REQUEST

Current Zoning: N1-A (neighborhood 1-A)
Proposed Zoning: N1-E(CD) (neighborhood 1-E, conditional)

Approximately 1.988 acres located at the deadend of Pickway Drive, west of North Graham Street.

The petition proposes to develop five duplex buildings on parcels that are mostly vacant with one single family home.

**PICKWAY TOWNHOMES (2023-095)**  
**REZONING SITE LAYOUT PLAN**  
 2541 PICKWAY DRIVE, CHARLOTTE, NC  
 MEN IN MOTION, LLC  
 PROJECT NO. 23006  
 PROJECT MANAGER: KYU

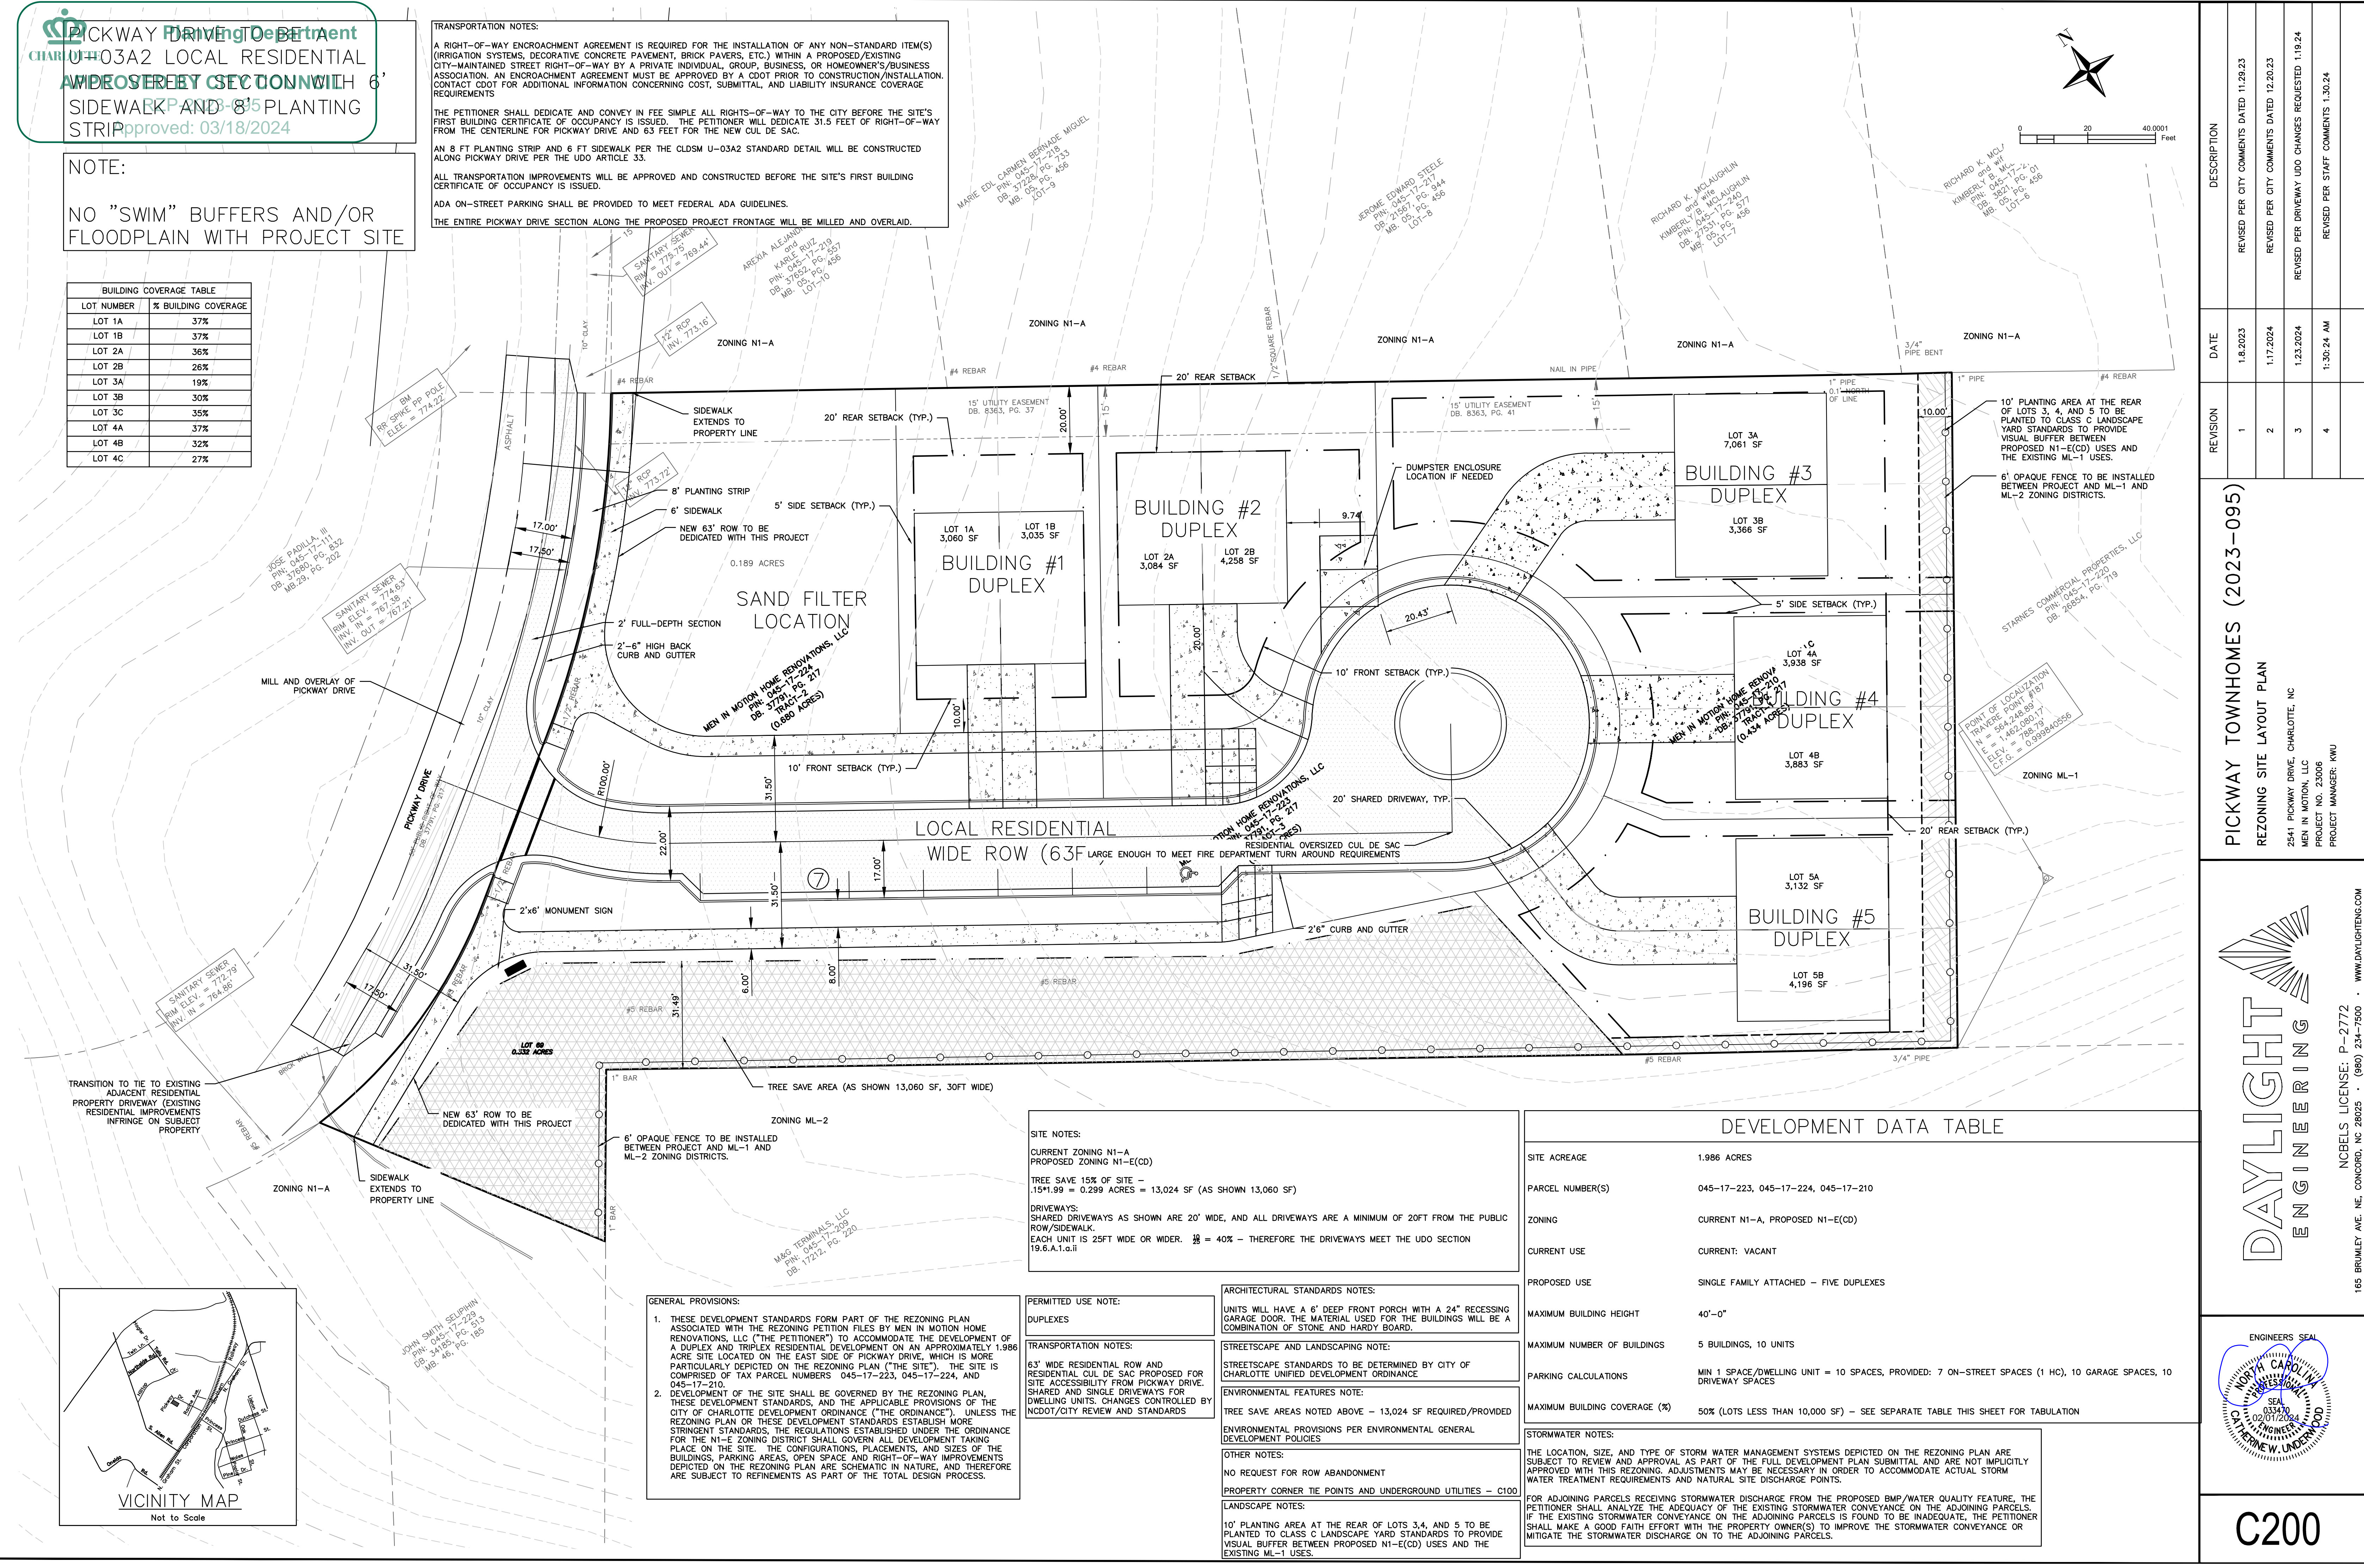
- ~~1. Revise site plan and conditional notes to commit to dedicate 31.5 feet of right of way from the road centerline. Label and dimension the right of way from the road centerline on the site plan.~~
Addressed
- ~~2. Revise conditional notes to commit to an 8' planting strip and 6' sidewalk per the CLDSM U-03A2 along Pickway Drive per UDO Article 33. The sidewalk should extend across the entire frontage, including at the intersection of the proposed public street and Pickway Drive as well as fully to property line.~~ **Addressed**
- ~~3. Revise conditional notes to commit to milling and overlaying the entire section of Pickway Drive across the development frontage.~~ **Addressed**

- ~~4. Specify in the conditional notes what type of planting standards will be provided in the rear setback against PID 04517220 and along the side of lot 4C. Consider adding conditional notes for planting standards that mirror the standards outlined for Class B or Class C Landscape Yards. Add a 6' opaque wooden fence along the site's boundary against PID 04517220.~~ **Addressed**
- ~~5. Add a 6' opaque wooden fence along the site's boundary against PID 04517209.~~ **Addressed**

~~6. Modify the driveways shown for the triplex buildings to be compliant with Article 19.6.A.1.a.~~

~~7. Correct the listed zoning of PID 045-172-20 to ML-1.~~ **Addressed**

~~8. Clearly distinguish and label each building as being on its own lot. Sublots for the individual units should be distinguished by dashed lines.~~ **Addressed**

Addressed
